<b>Please ask for</b>	<b>Telephone</b>	<b>Our Reference</b>	<b>Your Reference</b>	<b>Date</b>
Ellen Carr Planning Services	01832742020	NE/22/00427/QRV/		03 <sup>th</sup> March 2023

**Proposal: First floor side extension.**

**Site Address: 137 Huntingdon Road, Thrapston, Kettering, NN14 4NG**

Project:			137 Huntingdon Road
Client:			Anthony Binns
Drawing:			Arboricultural Site Plan (Proposed)
Drawing Ref:	Rev:	Date:	
P2468-ASP02	V1	30/06/2022	
Scale:	Drawn By:		
1:200 - A3	J. Sinclair		
Based on:			Proposed Site Plan

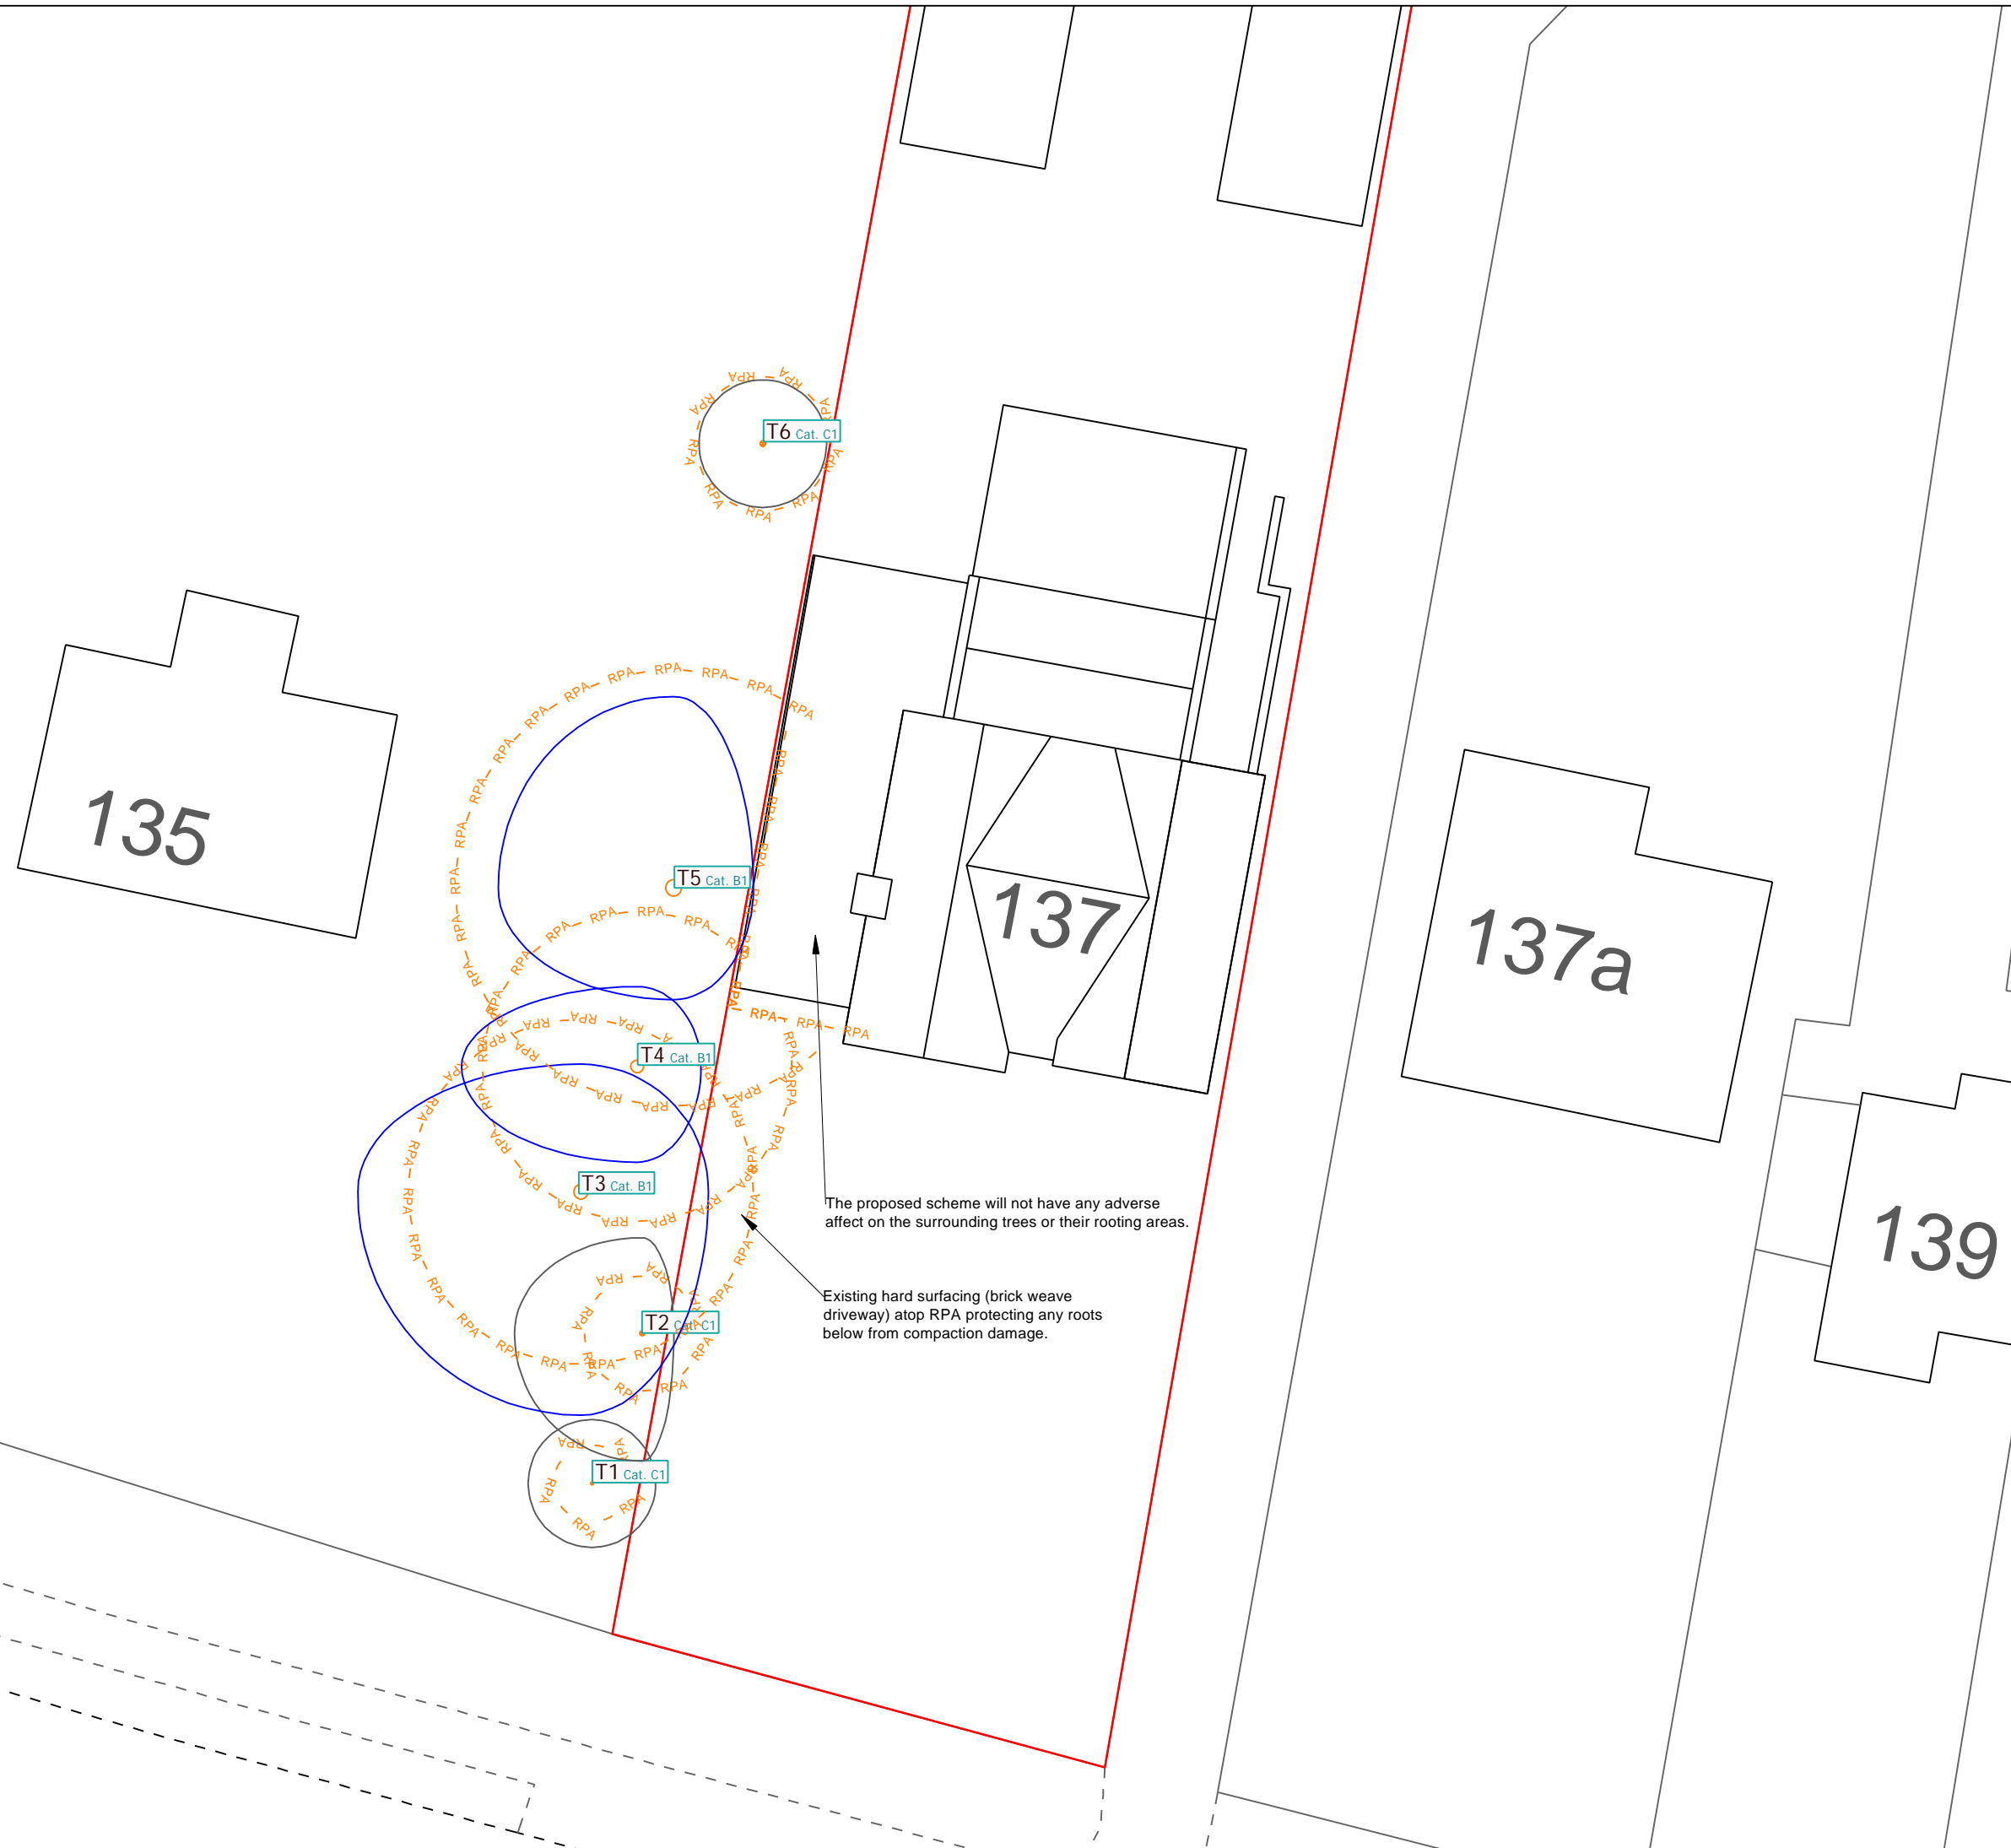
*'I've reviewed the Arboricultural report by Ligna, and while the report accurately represents the locations, sizes and conditions of the trees, it does not address the issues of long term relationship between the proposed first floor extension and the trees. At 3.4.1.1 the report states that "none of the trees are considered to possess a significant potential for a negative shading on the proposed extension". At 3.4.2.1 it states that "The layout of the scheme has been designed with consideration of the location and growth of potential of nearby trees. Owing to such, no noteworthy contention between tree canopies and property are anticipated. At 3.4.3.1 it states that "additional unreasonable tree-related nuisances, such as leaf and fruit fall, are not thought to exist beyond what might generally be considered as acceptable limits." This report hasn't explored in details the issues of post development pressure for work to the trees, and the long term sustainability of the potential relationship between the trees and any extension of the first floor into consideration. This is the principal issue of concern. These trees particularly the one closest to the side of 137 Huntingdon Road tower above the property and needles and cones will regularly fall from them, onto the existing property, which may be more noticeable if the living areas of the property are moved closer to the tree. The trees are going to require pruning periodically as they will grow from the reduction pruning points over the existing boundary wall and roof of the property. The sheer size of the trees, towering above the side of 137 Huntingdon Road, the noise they make, the movement in strong winds, the regular needles and cone fall, in combination with the shading, will have an impact on the use and enjoyment of the property, which has been simply dismissed by the report's author. Maybe we could take a look at the layout of the proposed first floor extension to see how it has been designed with consideration of the location and growth of potential of nearby trees? Then provide our opinion on if this can be supported. It's going to be very difficult for me to support an application based on this report.'*

*'I've reviewed the additional comments made in response to my comments on the original Arboricultural report by Ligna, and nothing in the statement changes my view that any further extension of living space closer to the trees on the first floor will only result in the creation of a completely unsatisfactory relationship between the neighbouring Pine trees and the property.'*

*There is clearly the potential for post development pressure in the future to once again harshly prune or fell these trees, due to the sheer size and proximity to the property, and for this reason I would not be able to support an application on this basis.'*

FF No. 137 HUNTINGDON ROAD NN14 4NG  
**FIRST FLOOR PLAN - PROPOSED**  
 SCALE 1:100

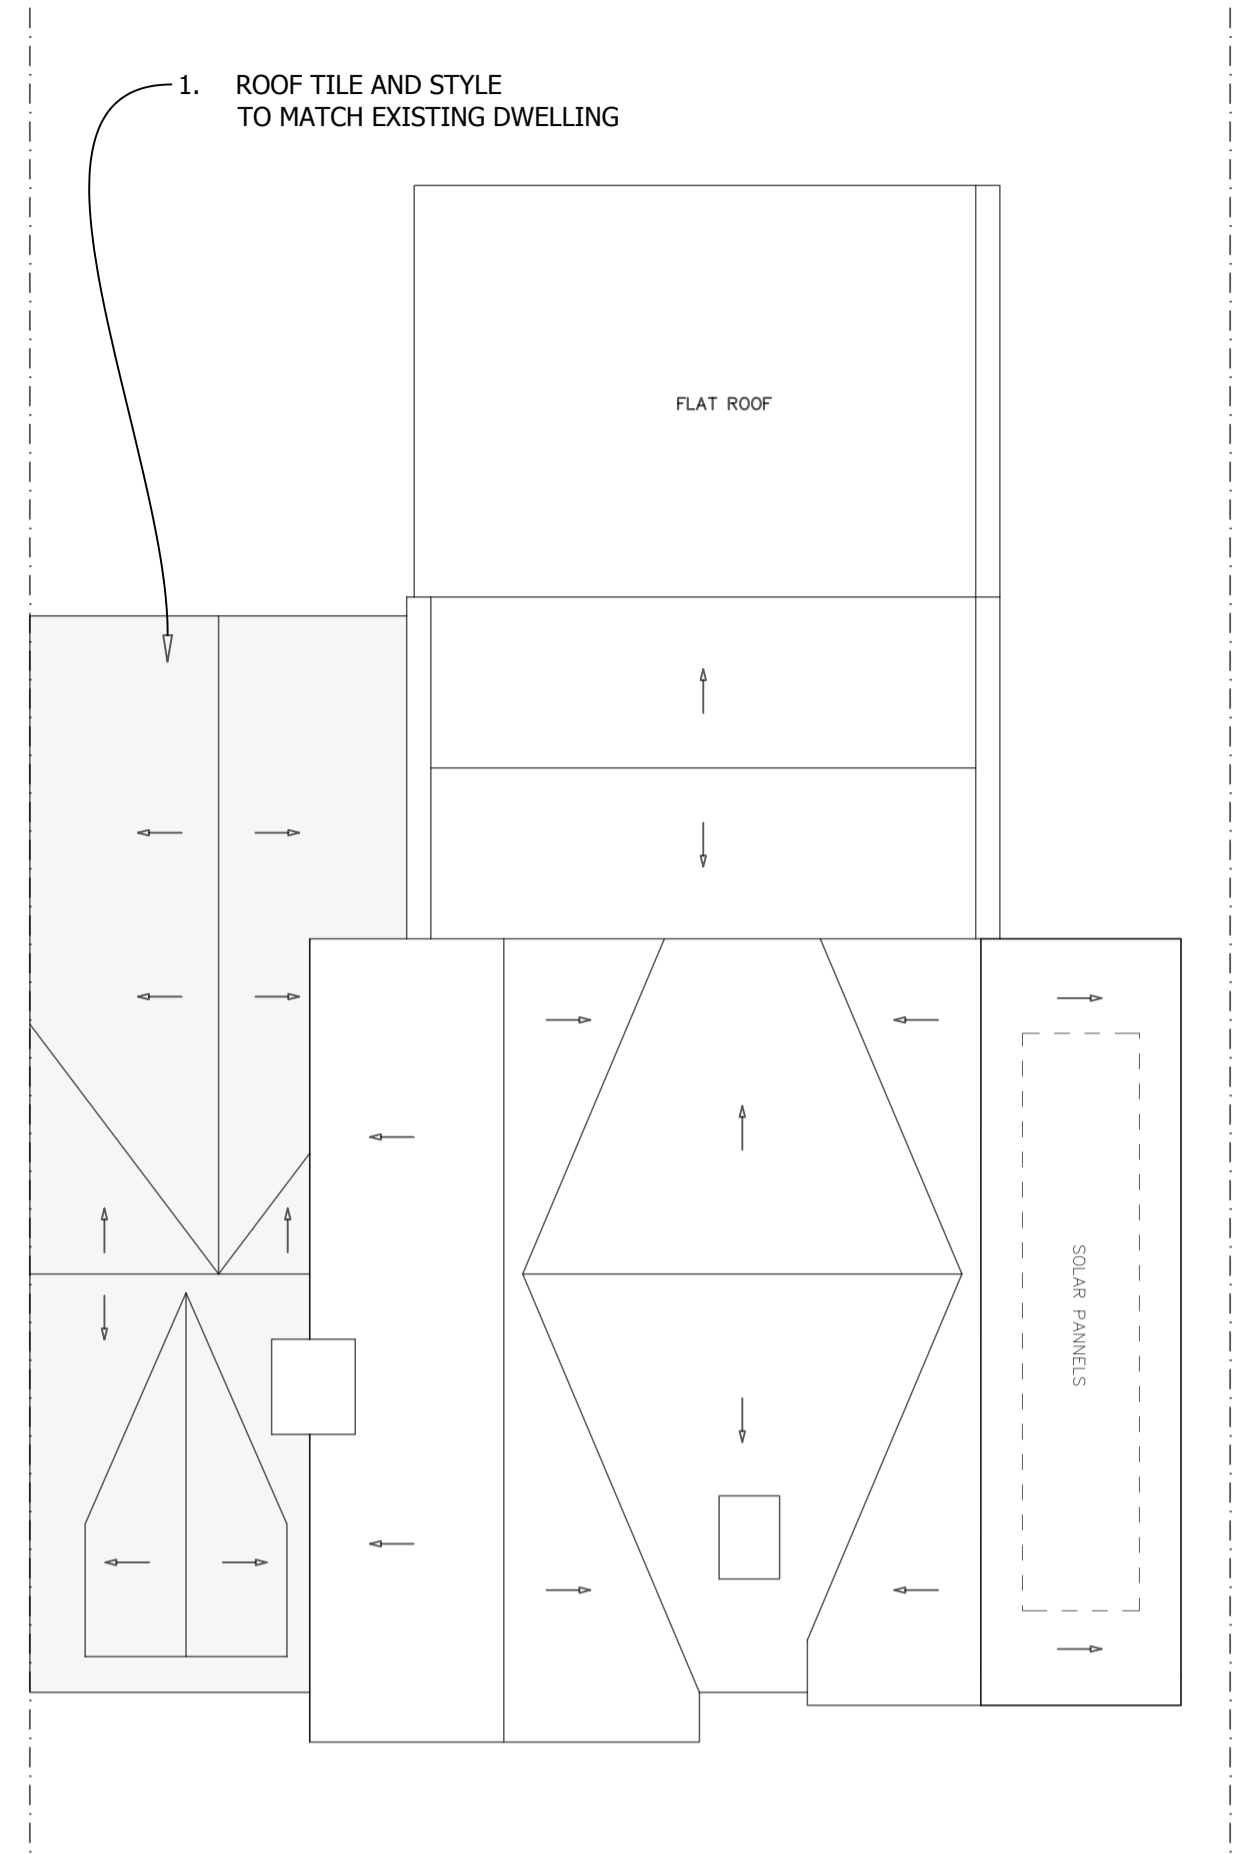
In regard to residential amenity, if a planning application were to be submitted, a site visit would take place to understand the screening/boundary treatment currently in place on both neighbouring boundaries to assess the full effect of the proposal in regards to overlooking and loss of privacy. It is noted that the proposed windows on the western elevation would be obscure glazed which would be required if planning permission was applied for.

FE No. 137 HUNTINGDON ROAD NN14 4NG  
**FRONT ELEVATION - PROPOSED**  
 SCALE 1:100

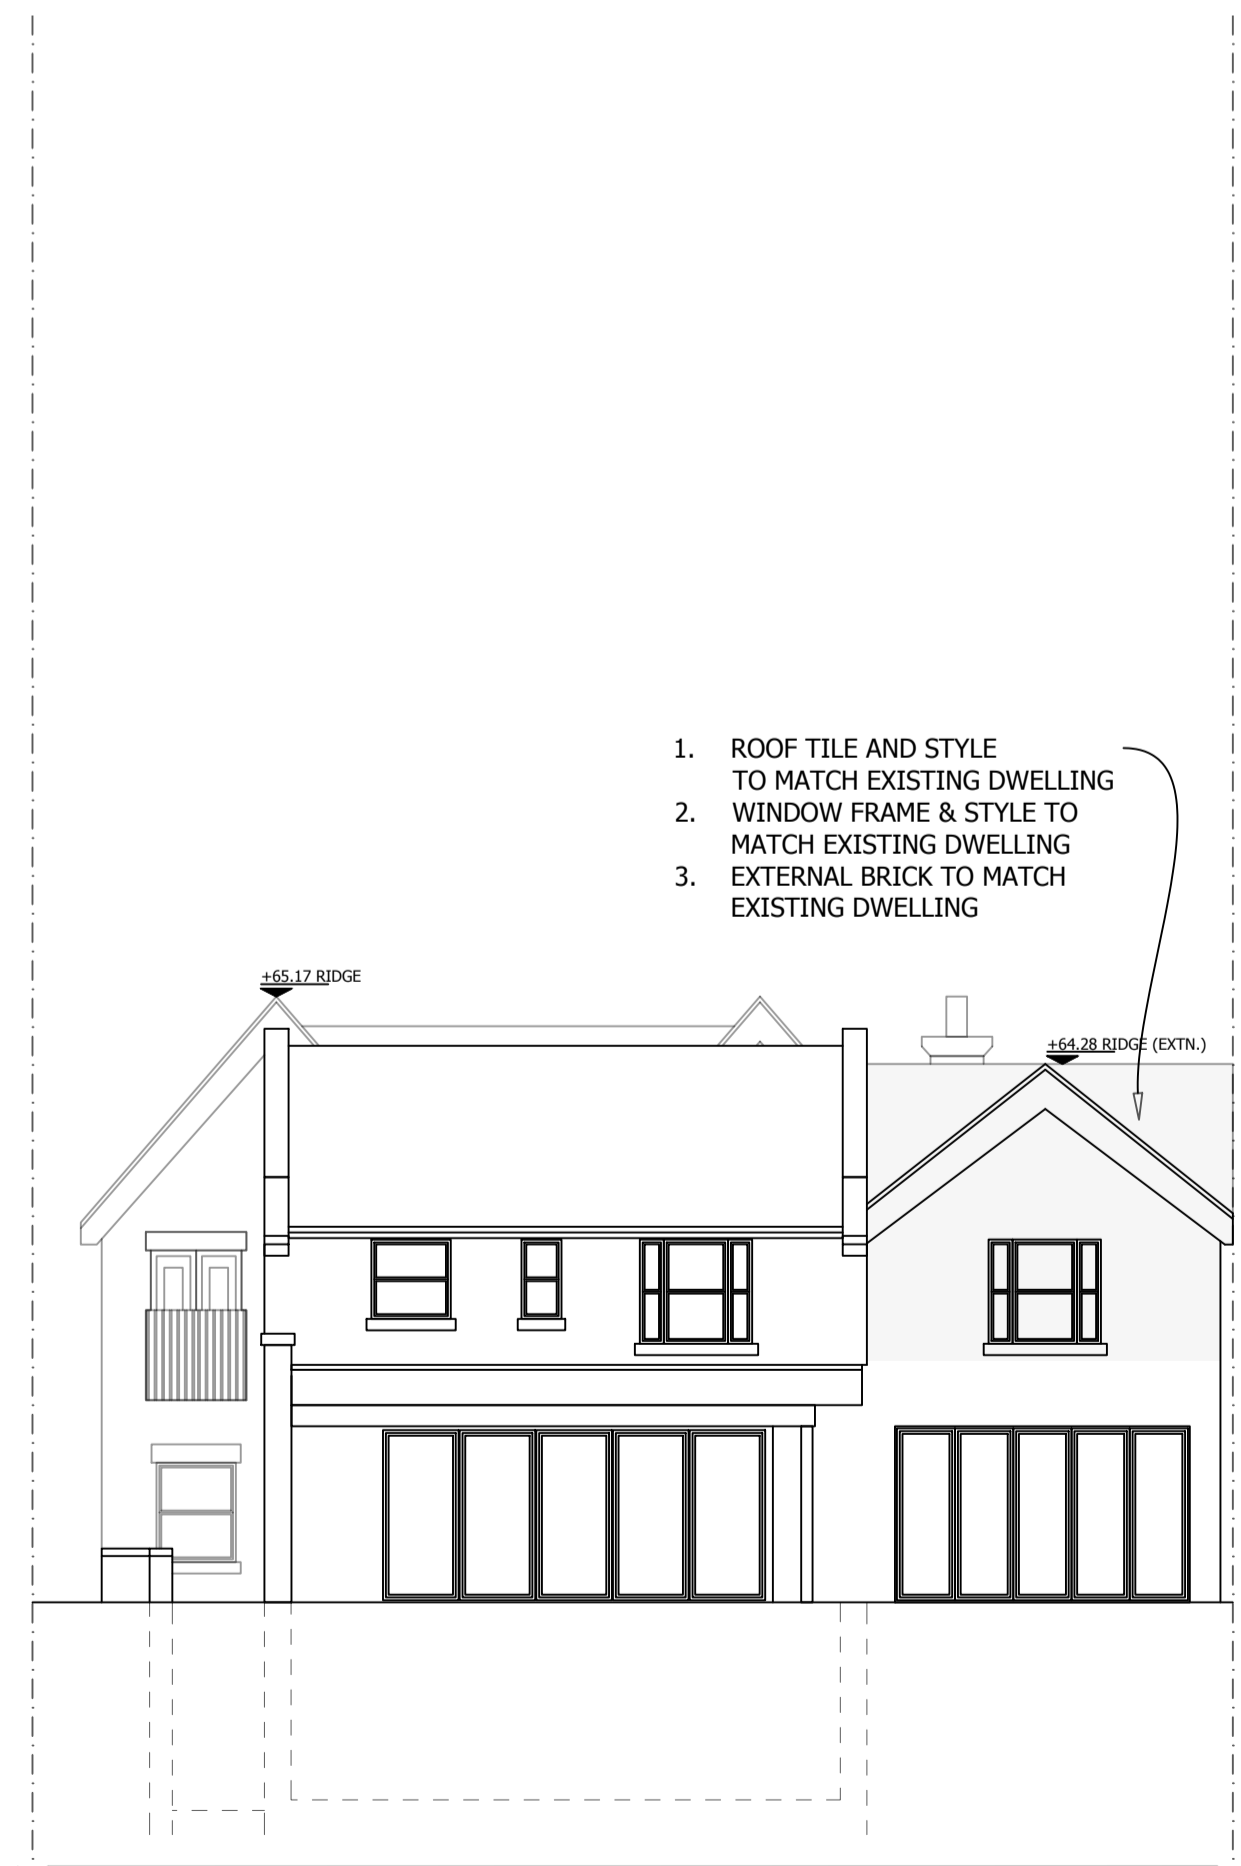
I would recommend that matching materials are used to be sympathetic to the existing house to compliment the design and appearance within the street scene. My preference between the two schemes submitted is the second scheme, however, it still requires some design tweaks. The

design of the existing dwelling is very symmetrical and building a 1<sup>st</sup> floor extension is going to unbalance the house. It is stated within our Residential Extensions SPD that any 2 storey extensions should be slightly stepped back from the front elevation of the existing house and then stepped down from the existing ridge which could be achieved and would also make the extension an addition to the main house rather than appearing to stretch what's already in place.
